Subject: Environmental Impact Statement - Residential development with in-fill affordable housing at 23-31 Dover Road, Rose Bay (SSD-86017721)

CPHR advice on EIS - Residential development with in-fill affordable housing at 23-31 Dover Road, Rose Bay (SSD-86017721)

**Figure 2 :
Peak Floodwater Depths and
Levels for the 100 Year ARI
Flood for Existing Conditions**

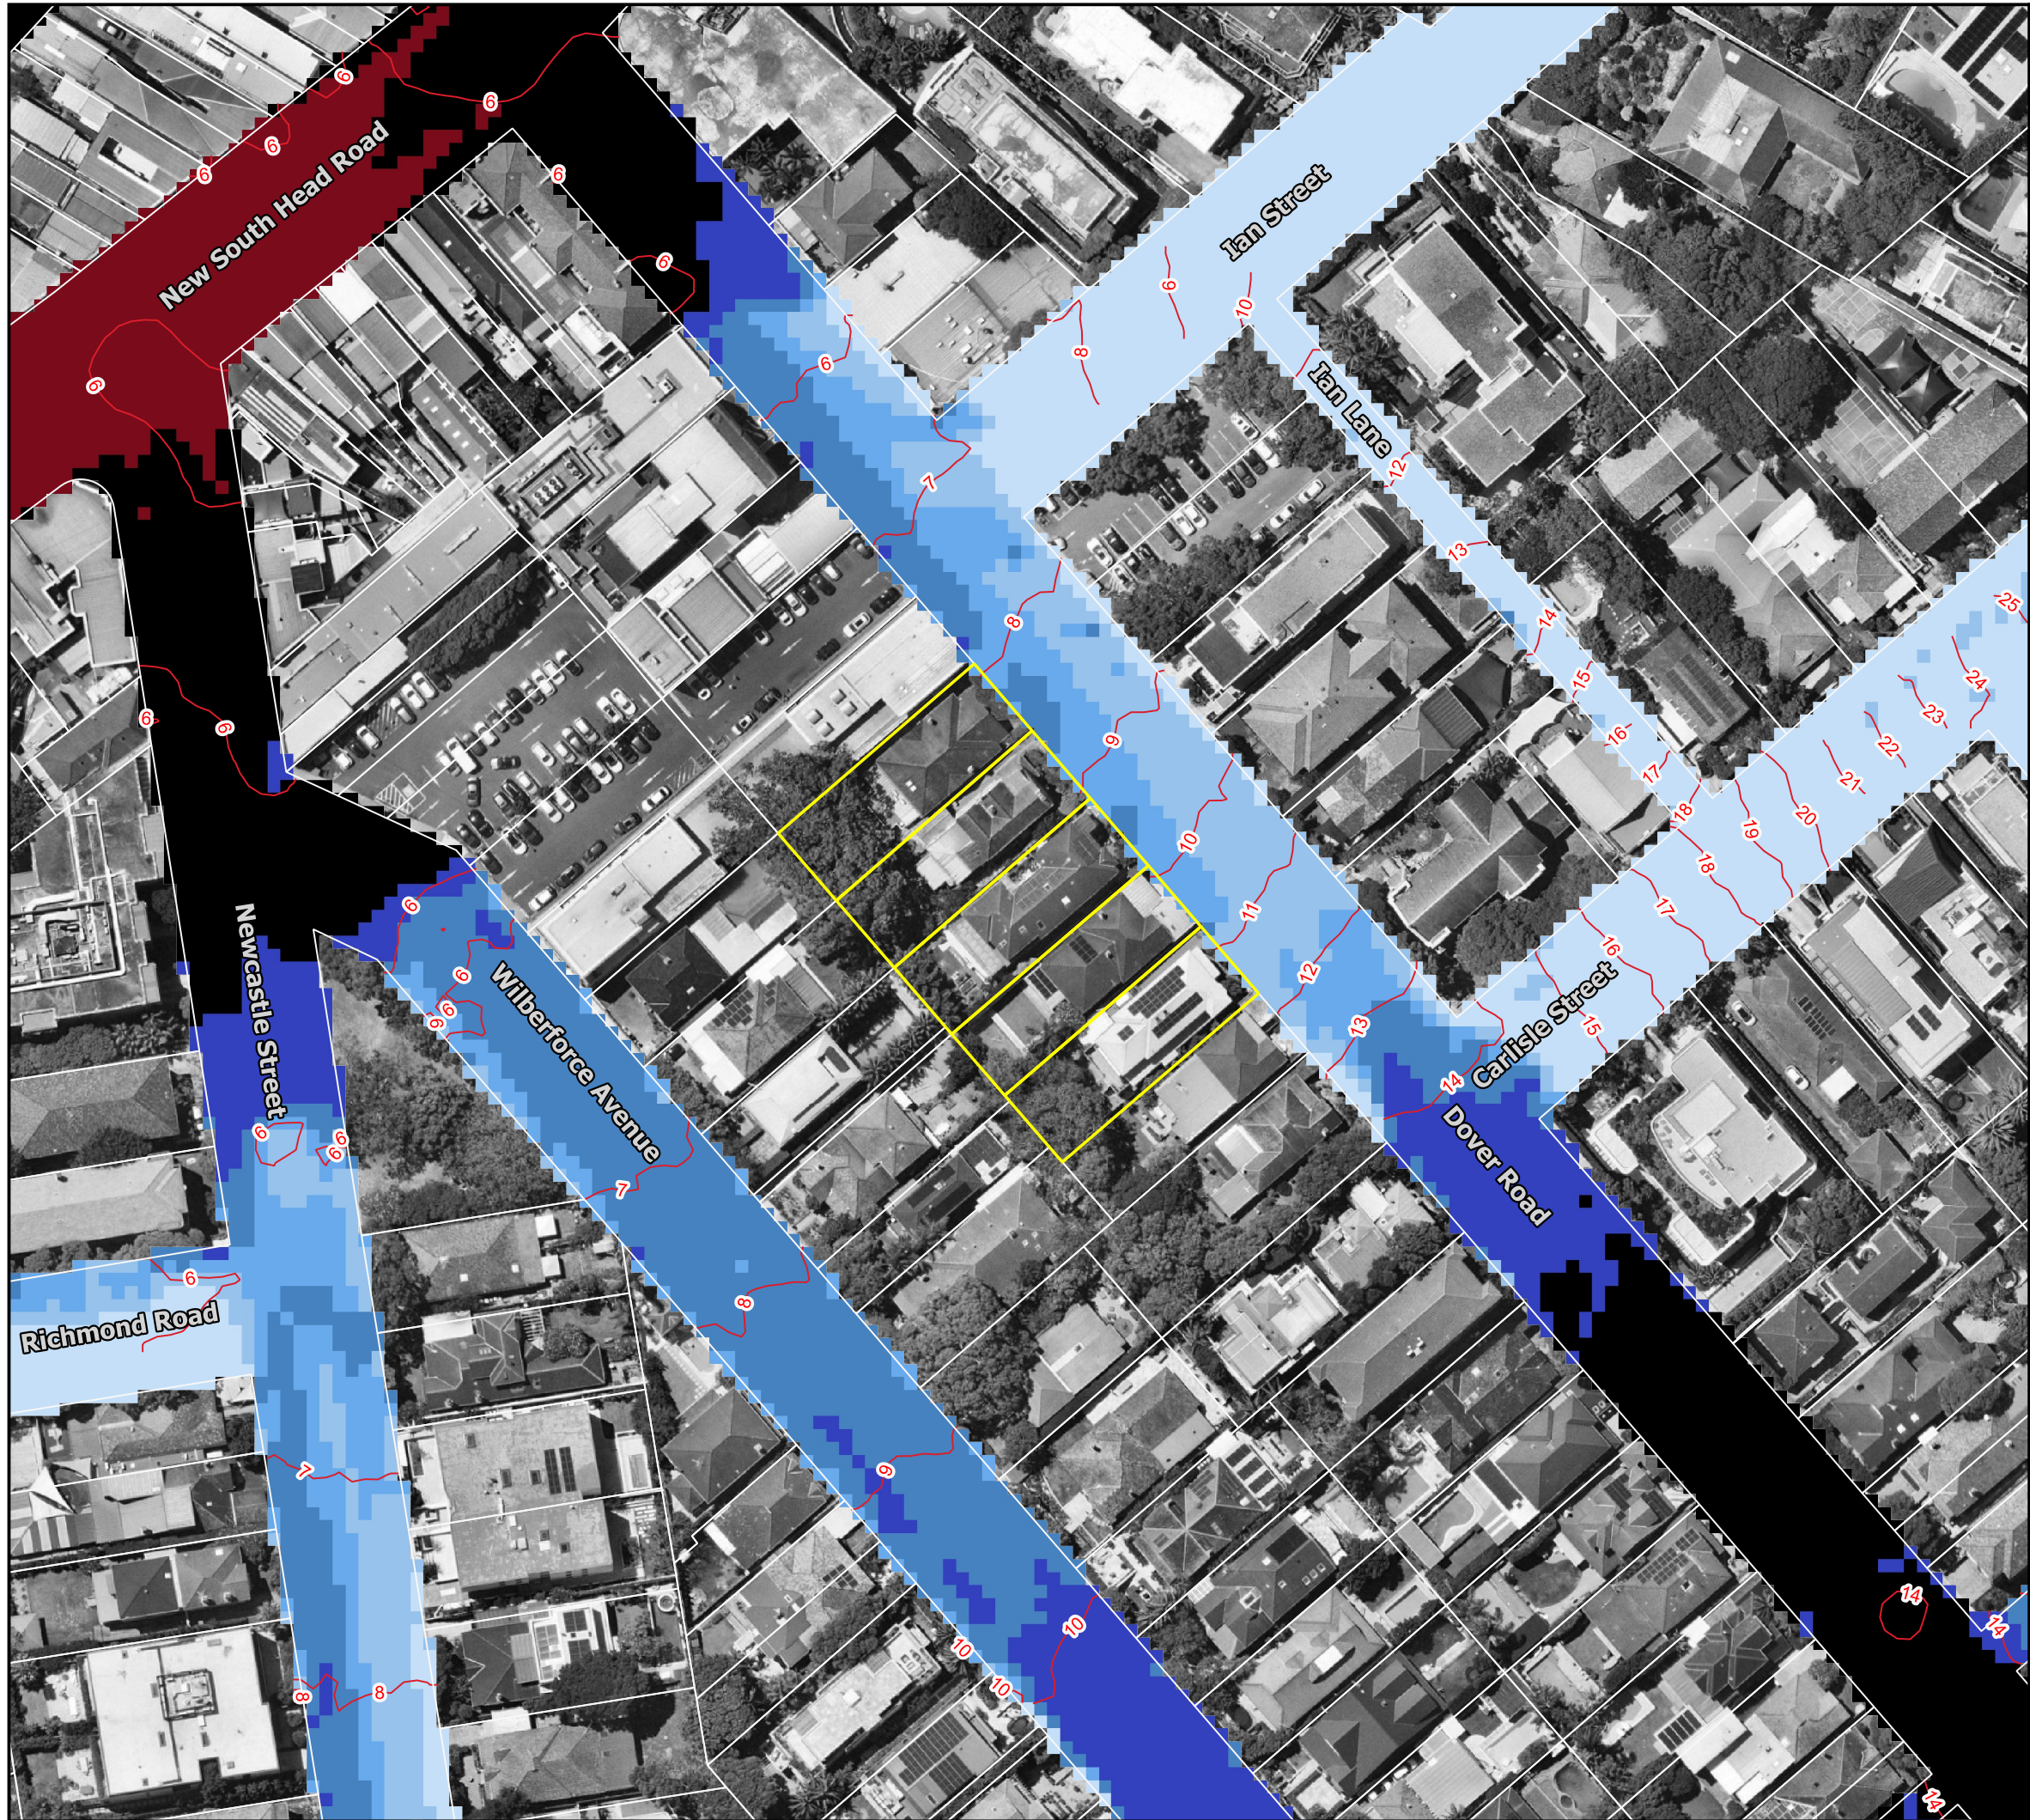
1	<i>The FIRA does not assess offsite impacts of the development</i>	The FIRA has been based on the <i>Rose Bay Floodplain Risk Management Study and Plan</i> (WMA Water, 2014) (Rose Bay Flood Study and Plan). The Rose Bay Flood Study and Plan (prepared for Council) assumes that future development would stop water from public land from entering private property. The Rose Bay Flood Study and Plan therefore shows no flood water on private land and confines all flows to public property and roadways. This illustrates worst case flood levels and hazards on public roads however does not reflect the true flood behaviour where flood waters do enter private land. The proposed development has a large impervious footprint and proposes changes to site topography and flow paths including taking preventative measures to keep flow on the roadway. This will change the existing flood behaviour and has the potential to impact properties both upstream and downstream of the site. The Rose Bay Flood Study and Plan indicates that properties downstream of the site are already subject to over floor flooding in frequent events. Based on the provided FIRA, the subject development is likely to have adverse offsite impacts which have not been mitigated. Given the above, the Rose Bay Flood Study and Plan is not adequate to inform the FIRA for the subject development. Recommended action: 1. A new site-specific flood study be prepared in accordance with Understanding and managing flood risk: Flood risk management guideline FB01 (DPE, 30 June 2023). The study must incorporate an extended area to include upstream, downstream and adjacent properties. 2. The new flood study must be used in the preparation of a revised FIRA.

3	<i>Flood planning requirements</i>	The findings of the Rose Bay Flood Study and Plan have been used to set flood planning levels and floor levels for the development. These levels are based on flows on the adjacent roadway only and may not be reflective of risks arising from overland flows. Recommended actions: • Update flood planning requirements for the development from offsite flooding sources other than the roadway • Ensure that overland flow from adjoining properties is not obstructed by the development.
	<i>Extent and Timing</i>	Pre-determination
